# Planning Application Response

## Ecology

**To:** Caroline Ford  
**District:** Cherwell  
**From:** Laura Grant, Ecology by Design  
**Site:** Land On The North East Side Of Gavray Drive Bicester  
**Detail:** OUTLINE - Residential development for up to 250 dwellings including affordable housing and ancillary uses including retained Local Wildlife Site, public open space, play areas, localised land remodelling, compensatory flood storage, structural planting and access.  
**Application number:** 21/03558/OUT  
**Date sent:** 25 March 2022

### Recommendations: Further information required

drawing title
Plan EDP 1: Phase 1 Habitat Plan

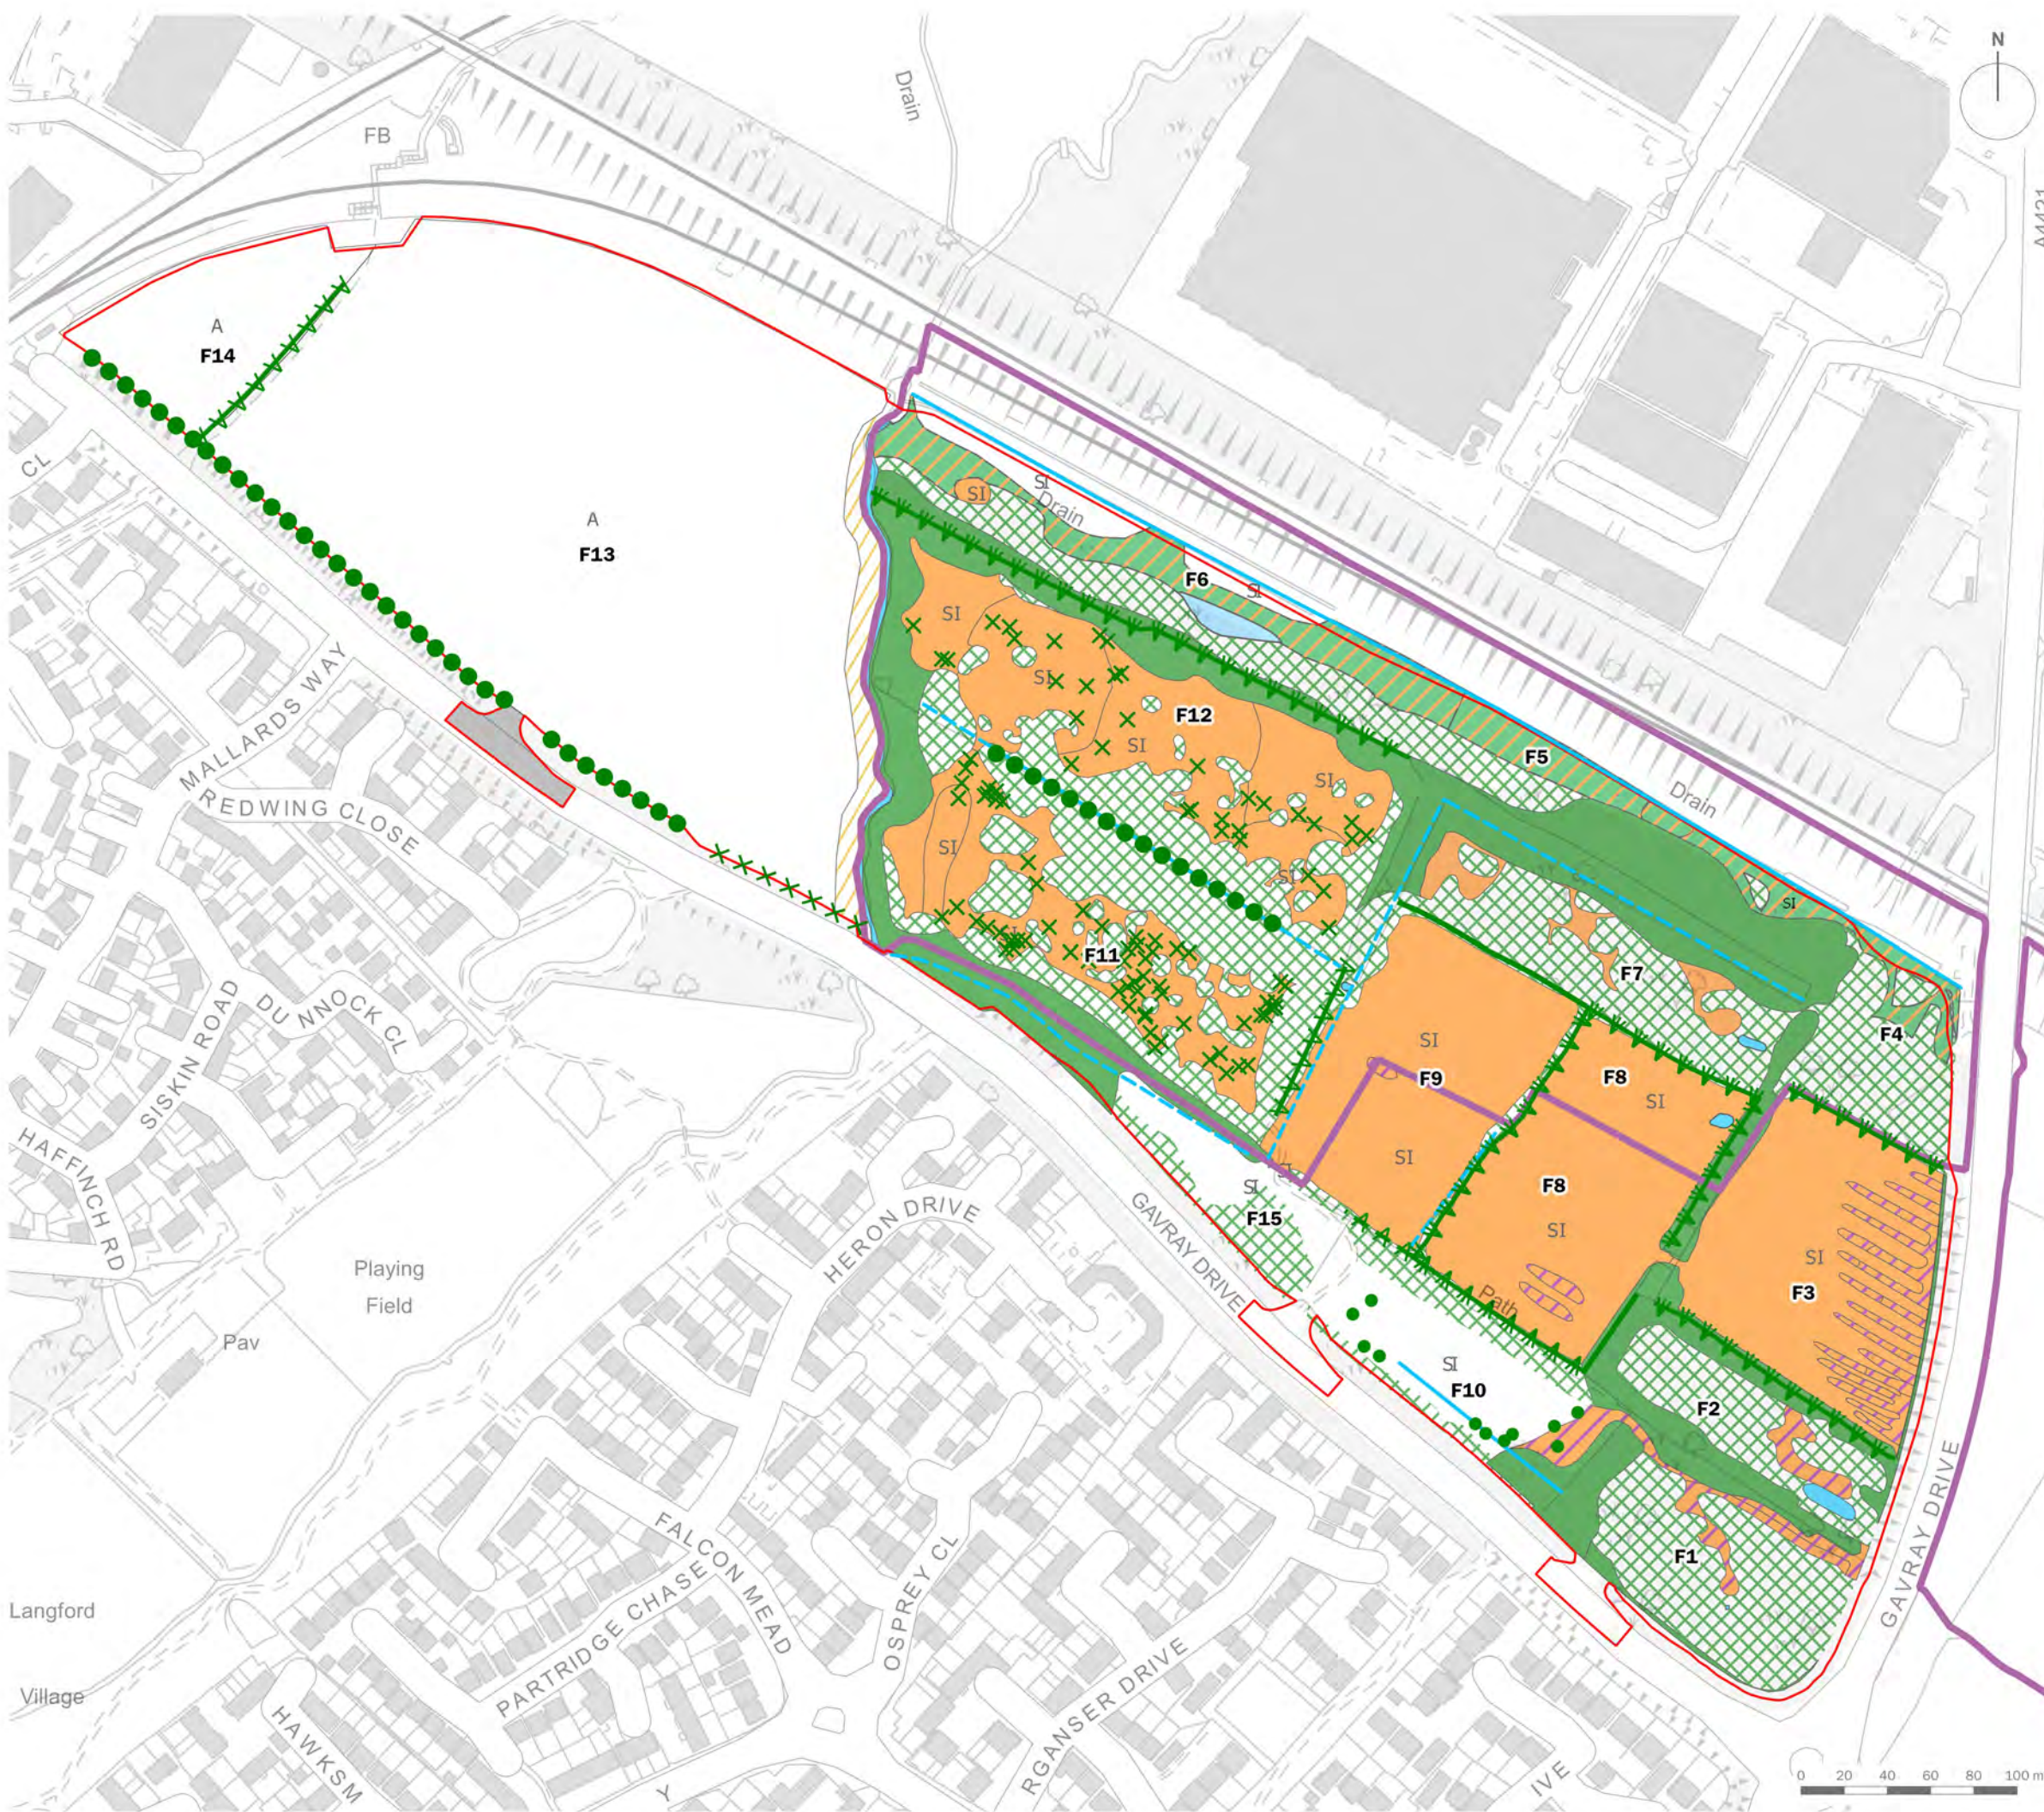
- U: No reptile survey results plan is included however, from tables it is evident 43 common lizard were present within F1, F10 and F15 (i.e. the eastern development area) in 2013 and disturbance and to a lesser extent habitat succession in F1 is likely to have resulted in only 3 having been recorded in 2020.
